Lower Thames Crossing

5.4.4.11 Draft Agreed Statement of Common Ground between (1) National Highways and (2) Transport for London (Tracked changes version)

Planning Inspectorate Scheme Ref: TR010032
Application Document Ref: TR010032/APP/5.4.4.11

Table 2.1 Matters

Drawing file: TR010032 / TR010032-005281-Additional Submission - Land Plan - v6 Deadline 5 - Sheet 45 - Visual Aide.pdf

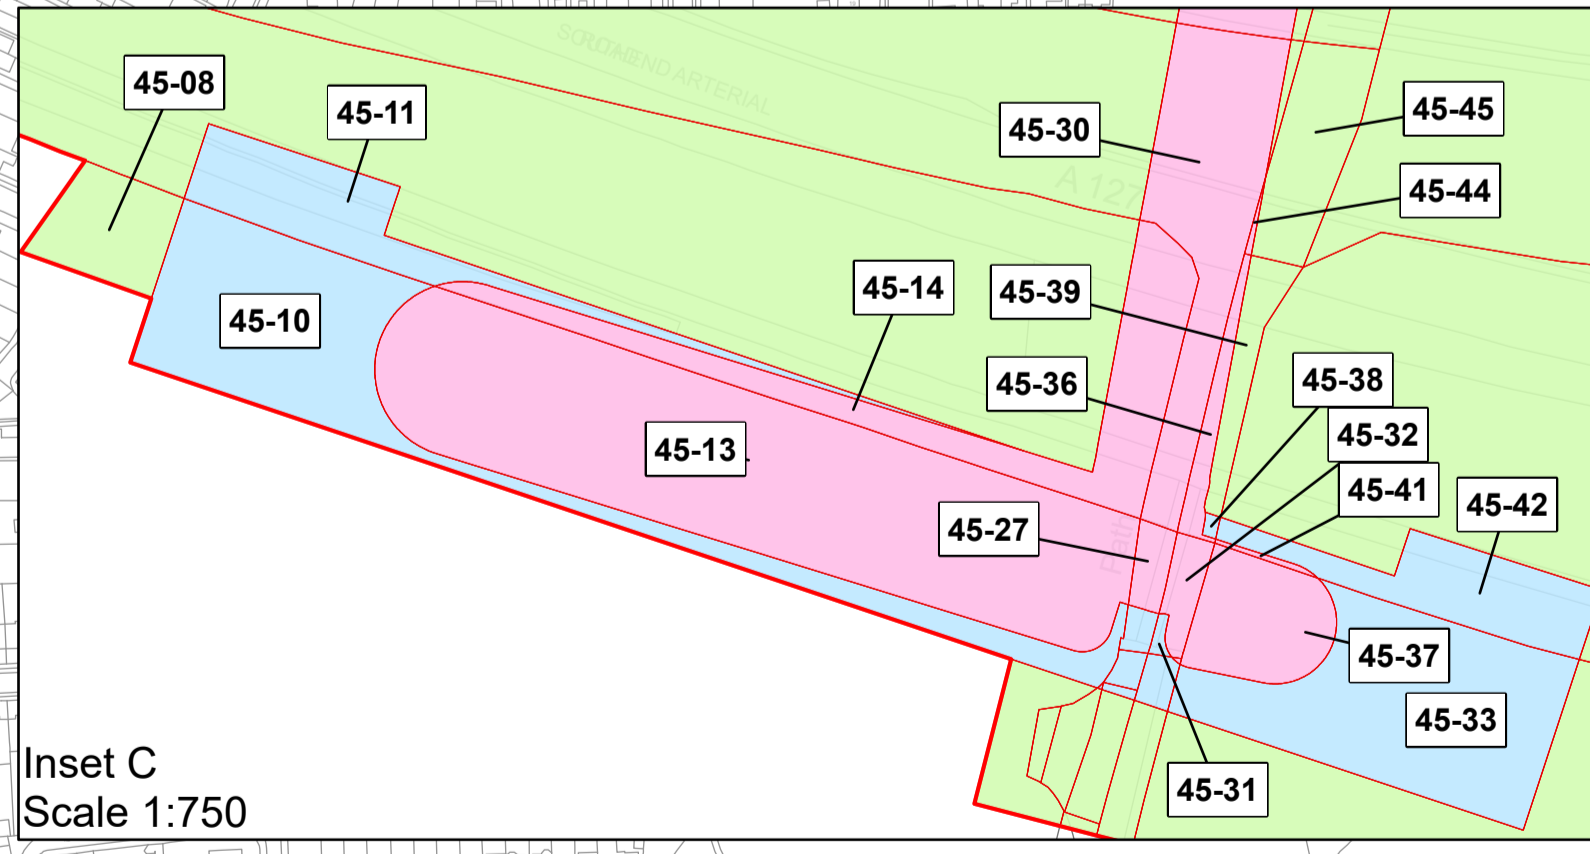
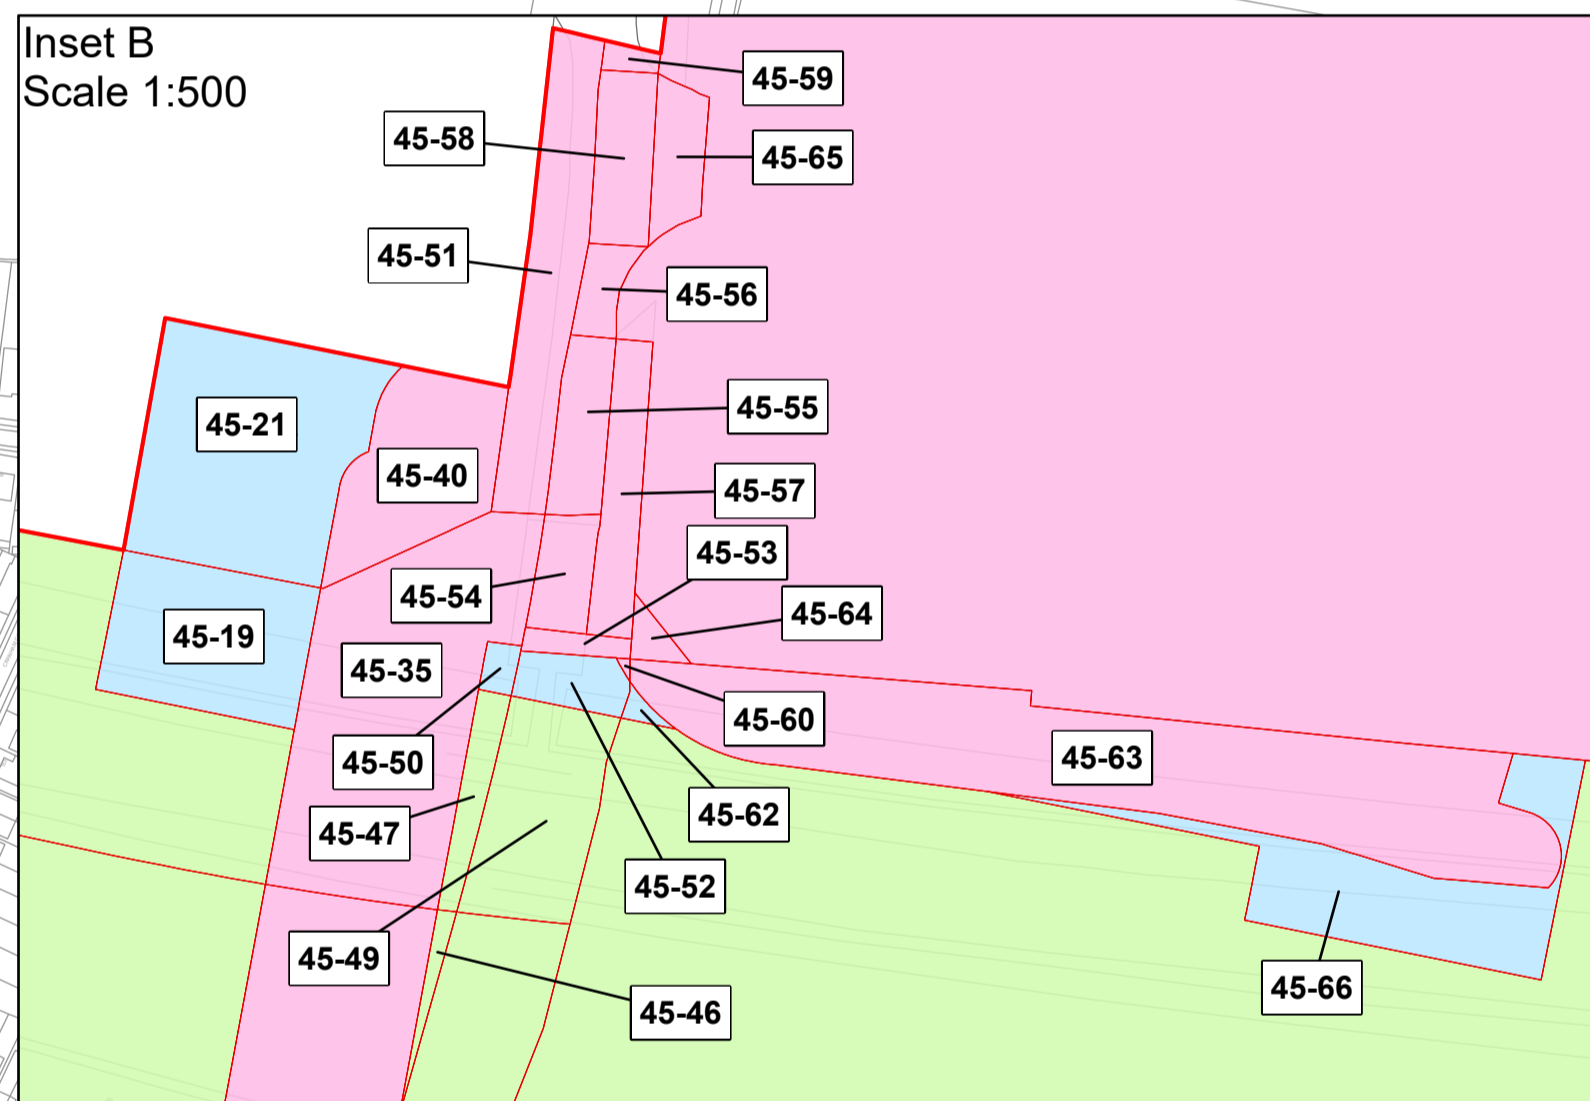
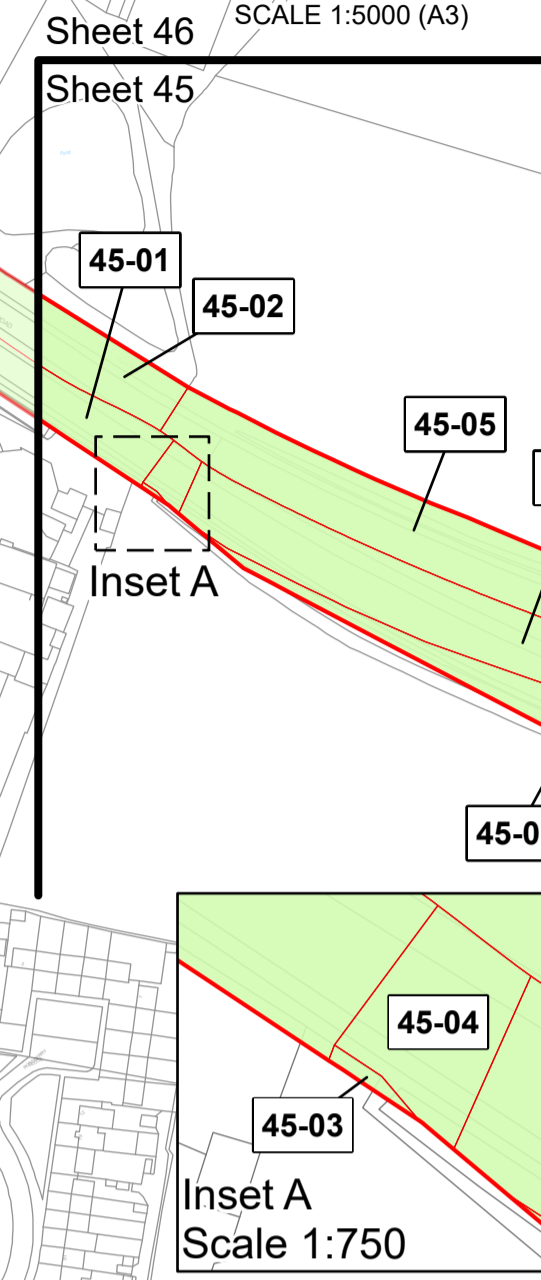
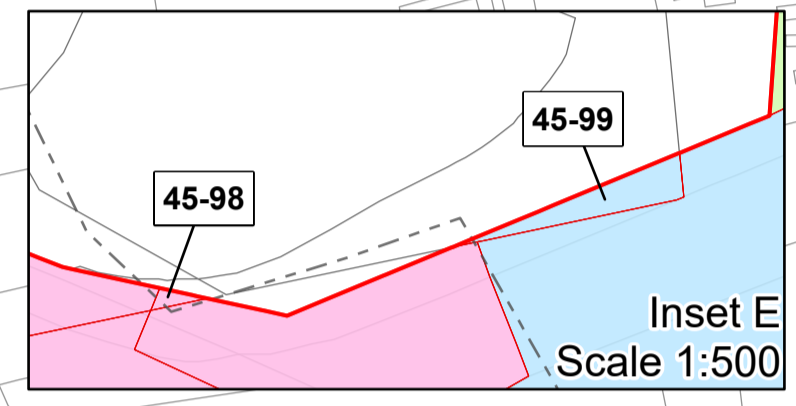
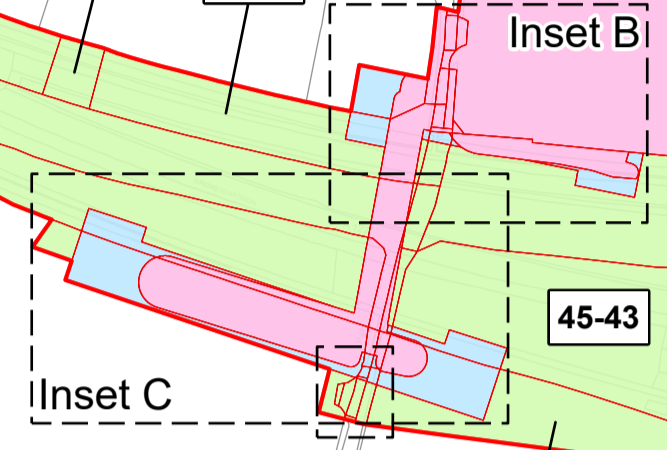
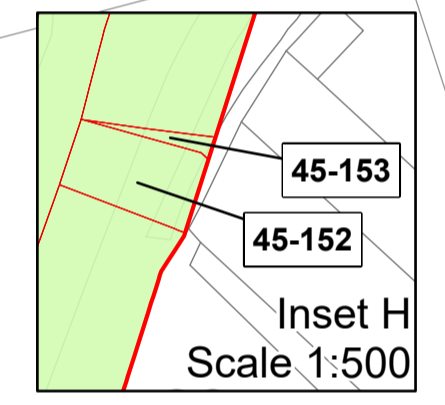
Consultation and engagement					
Adequacy of consultation	2.1.6	Transport for London is satisfied with the adequacy of consultation undertaken to date on the Project.	Noted.	N/A	Matter Agreed
Land and compulsory acquisition					
Land acquisition	2.1.7 RRE	Transport for London owns the freehold of certain parcels of land within the DCO application boundary around J29 of the M25 and relating to the A127.	The land use to the west of junction 29 has been amended to address these concerns and the majority of Transport for London's titles are now temporary use. There remain some areas where the Project requires temporary possession of land with the permanent acquisition of new rights for	Sheets 45 & 46 of the Land Plans [REP5-008] draft DCO [REP6-010]	Matter Under Discussion

Topic	Item No.	Transport for London Comment	The Applicant's Response	Application Document Reference	Status
Permanent vs temporary acquisition		<p>The Land Plans from the previous application documents shared with Transport for London (October 2020) showed most of the land west of the roundabout within the order limits and the TLRN as it passes the roundabout as permanent acquisition. This would suggest that National Highways intends to take on responsibility for this part of the A127. However, the draft DCO that was submitted shows that National Highways are not intending to reclassify any part of the main carriageway of the A127. Permanent acquisition is therefore not required and the powers sought should be for temporary possession only at most but even those powers should be limited.</p> <p>Where the Applicant considers it needs to acquire Transport for London highway land or rights over such land to deliver the Project, Transport for London requires that such land over which Transport for London will remain highway authority should be returned to Transport for London's ownership at no cost following completion of the works. Transport for London raised this matter in its relevant representation where it requested an amendment to the draft</p>	<p>the diversion of utilities. Permanent acquisition of land is also required for a small section of route alignment and for the construction of the new walking, cycling and horse riding (WCH) bridge structure to the west of junction 29. It is agreed that the Applicant and Transport for London will progress discussions to return any permanently acquired land to Transport for London post construction, including the proposed WCH structure which Transport for London shall be responsible for maintaining.</p> <p>These issues were discussed at a meeting on 17 December 2021 (with subsequent communications between the Applicant and Transport for London Land & Property specialists) and the requirements for permanent acquisition of rights were explained and accepted. At the 2022 Local Refinement Consultation, Transport for London reported that the latest acquisition plans provided by the Applicant address many of the concerns previously raised.</p> <p>Details of the land required for the WCH bridge were discussed at a meeting on 20 March 2023 with land and property specialists and legal representatives from Transport for London and the Applicant present. A draft side agreement between the Applicant and Transport for London is currently being discussed which will include details of the mechanism for transfer of land between the Applicant and Transport for London and the land requirements. As noted by TfL, the</p>	<p>Design Principles [REP6-046]</p>

Topic	Item No.	Transport for London Comment	The Applicant's Response	Application Document Reference	Status
		<p>DCO, for this provision, but following discussions is now willing to consider its requirements on these matters being included in <u>protective provisions or a side agreement with the Applicant.</u></p> <p><u>The Applicant submitted draft protective provisions for the protection of local highway authorities at Deadline 4 which cover transfer of land. Transport for London is broadly comfortable with this aspect of the protective provisions. Amendments to the drafting were proposed by the local highway authorities at Deadline 6, after which subject to the Applicant's consideration, this matter may be able to become agreed.</u></p>	<p>Parties are in discussion in relation to the proposed side agreement in an attempt to address issues raised by TfL.</p> <p>At a meeting on 12 September 2023, further discussions were held including an update on the land required for the bridge and its maintenance, the proposed side agreement between the two parties, powers for utility maintenance and, as TfL notes, draft protective provisions <u>submitted at Deadline 4.</u></p> <p><u>The Applicant notes that the following design principles are relevant to potential maintenance arrangements for bridge structures:</u></p> <ul style="list-style-type: none"> • <u>STR.16 Bridge structures – WCH design: provides standards according to which WCH provision on bridge structures shall be designed.</u> • <u>PEO.03 WCH detail design: surfacing, signage, boundary treatments and access controls.</u> • <u>PEO.04 WCH detail design standards: provides the standards in accordance with which the Project's WCH routes shall be designed.</u> • <u>PRO.02 Integrated design: the detailed design shall be developed through a multi-disciplinary collaborative design process.</u> <p>It is agreed that the above-mentioned discussions on the final ownership and potential return of acquired land will occur post-DCO consent.</p>

Topic	Item No.	Transport for London Comment	The Applicant's Response	Application Document Reference	Status
			<u>The Applicant will consider TfL's proposed amendments submitted at Deadline 6 to the draft protective provisions for local highway authorities and update its response if necessary and appropriate in a subsequent version of this SoCG.</u>		
Impacts Impact of the Project on existing and future Transport for London assets	2.1.8 RRE	<p>Transport for London notes that any works to the TLRN are subject to article 10 of the draft DCO which provides that any highway or works to highway should be constructed to the reasonable satisfaction of the local highway authority and unless otherwise agreed with the local highway authority it will be maintained by and at the expense of the local highway authority from its completion.</p> <p><u>The Applicant submitted draft protective provisions for the protection of local highway authorities at Deadline 4 which cover aspects of the impact on local highway authority assets. Amendments to the drafting were proposed by the local highway authorities at Deadline 6.</u></p> <p>Transport for London is also discussing a side agreement with National Highways which may cover arrangements for handing over of assets to Transport for London.</p> <p>Transport for London also notes that, for any new or altered works or assets</p>	<p>As noted by TfL, the parties are in discussion in relation to the proposed side agreement in an attempt to address issues raised by TfL.</p> <p>The Applicant's 's position in respect of TfL's request regarding commuted sums is set out in item 2.1.11 of this SoCG.</p> <p><u>The Applicant will consider TfL's proposed amendments submitted at Deadline 6 to the draft protective provisions for local highway authorities and update its response if necessary and appropriate in a subsequent version of this SoCG.</u></p>	<u>Draft DCO [REP6-010]</u>	Matter Under Discussion
